TECHNICAL NOTE

Former Nestle Factory, Hayes

Response to LBH Transport Comments

14th August 2017

CAR PARKING LAYOUT: FUTURE EXPANSION - GROUND FLOOR PLAN

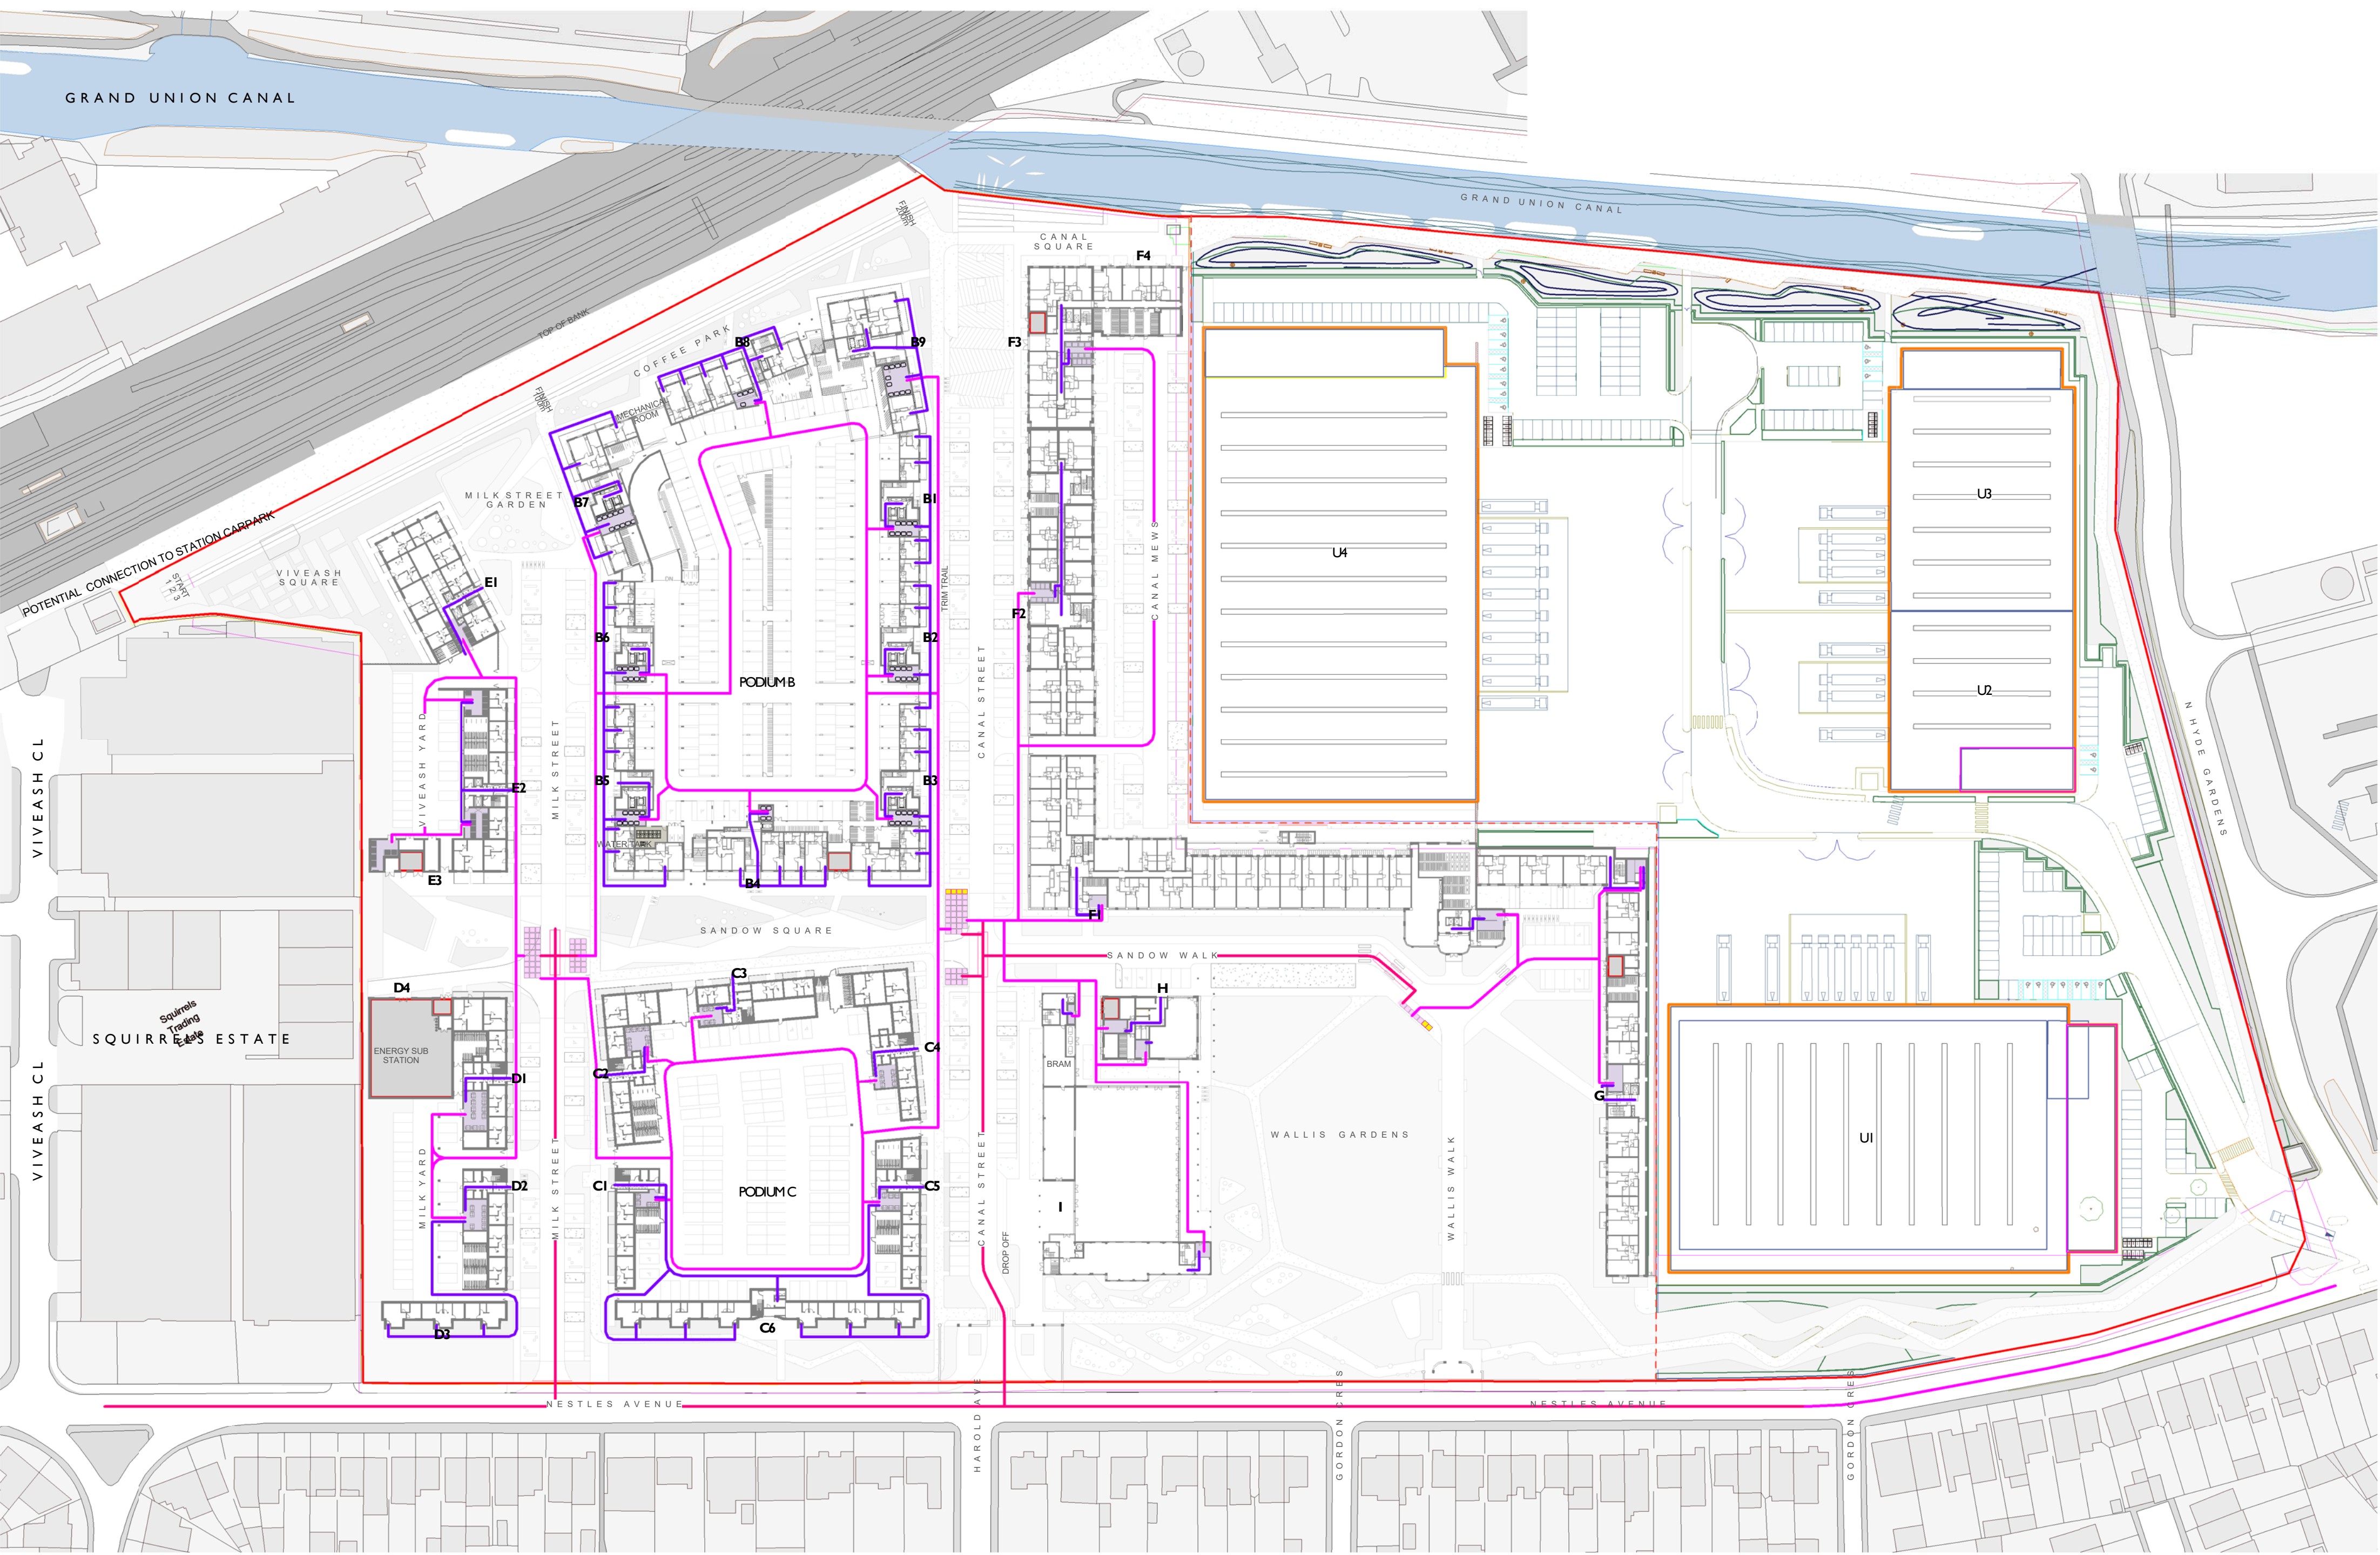
11.4 Further details are requested on the type and location of cycle parking for the proposals. It is intended that residential cycle parking provision is a mix of stacked stands (Josta type or similar) and larger stands of Sheffield type. Drawing No MP 721 submitted with the application identifies cycle parking locations and routes to access them. More detail of the cycle parking layouts for specific blocks can be seen in the following Drawings:
